Re: Inspection Item
Location: 79 JT McNeill Lane, Lillington, NC
JDSfaulkner Project No.: RDU2008326
Date of Inspection: 08/28/2020

A representative of JDSfaulkner arrived on site to observe the issues reported to us by the client which are presented, along with our recommendations, in this report.

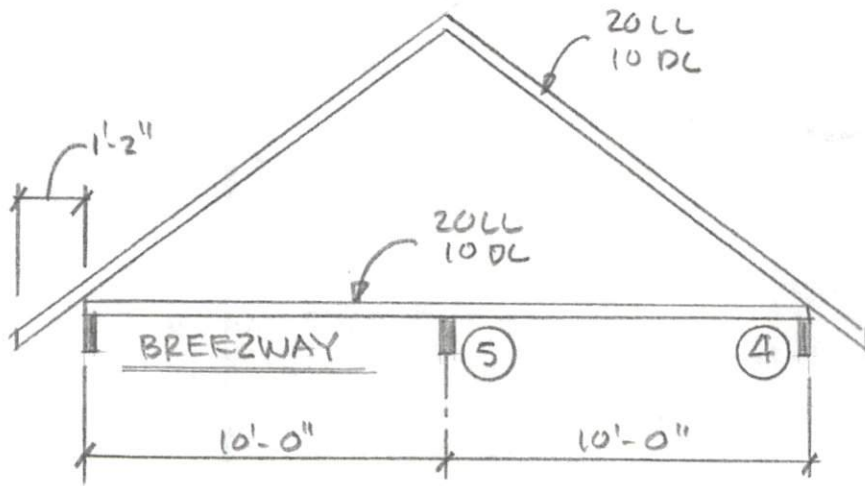
Contractor has requested evaluation of the (3) 2x10 header installed over the double garage doors with a max clear span of 9'-3" where the approved plans call for a (2) 2x10 header over the openings.

Based on our on-site observations and review, the (3) 2x10 header is adequate to support the anticipated loading conditions and no further action is required.
